Application no: H14/1232/01

Description: Alterations and extensions to  
provide first floor  
accommodation

Location: 30 Milestone Lane  
Pinchbeck

Amendment: Omit enlargement of bathroom  
Dwg.No. 210816A received 13 December 2001

GROUND FLOOR

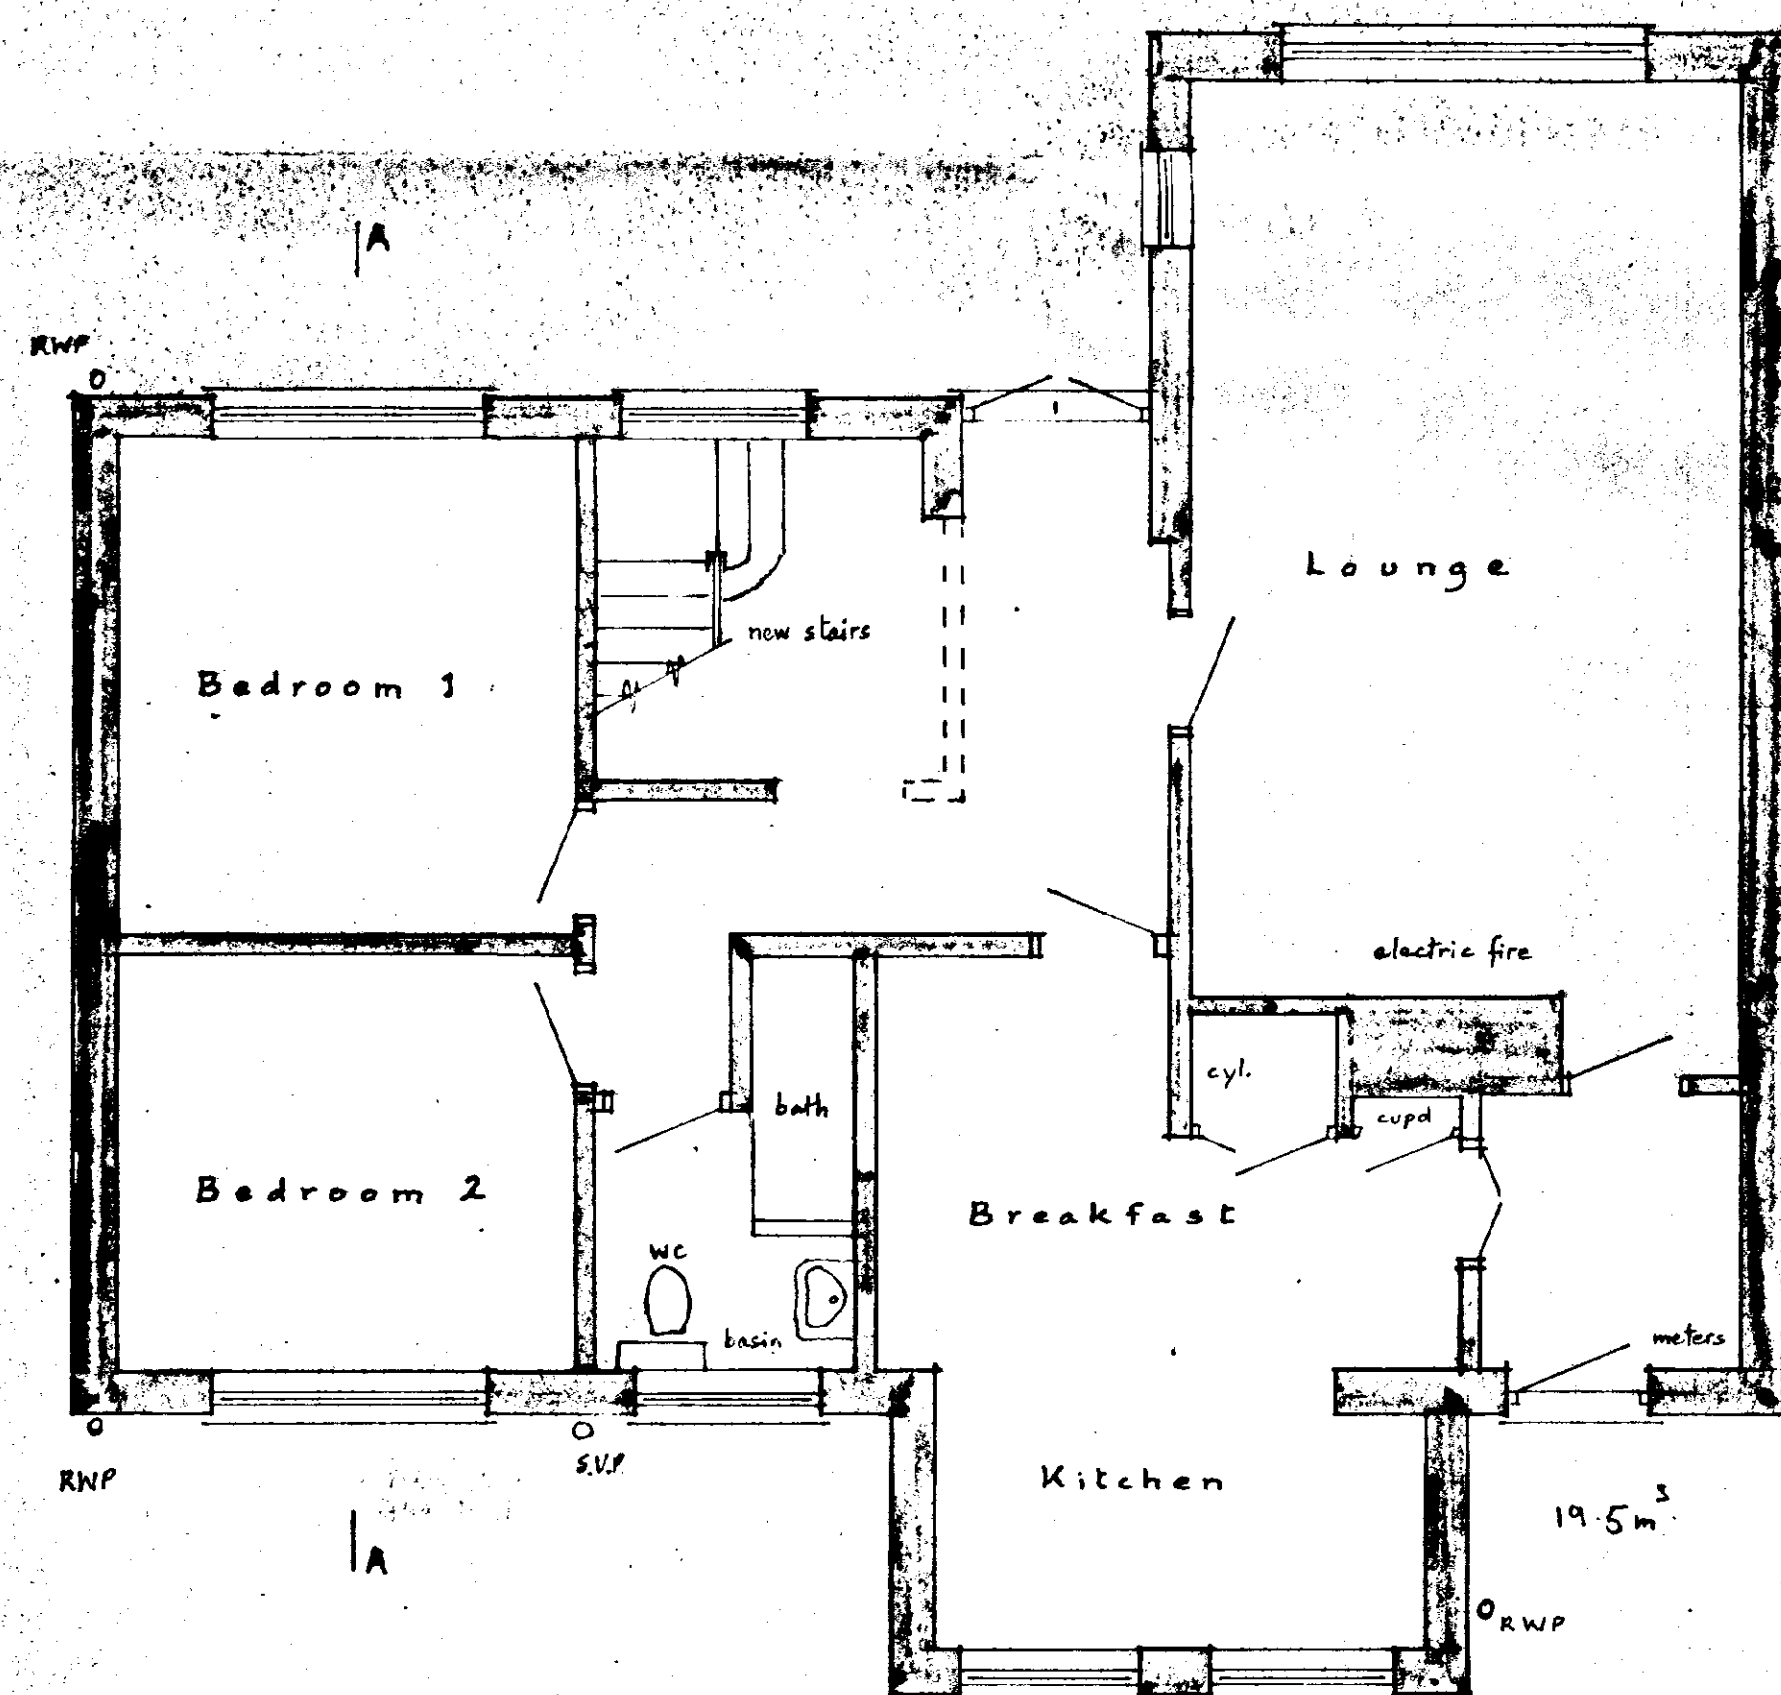
Omit enlargement of Bathroom
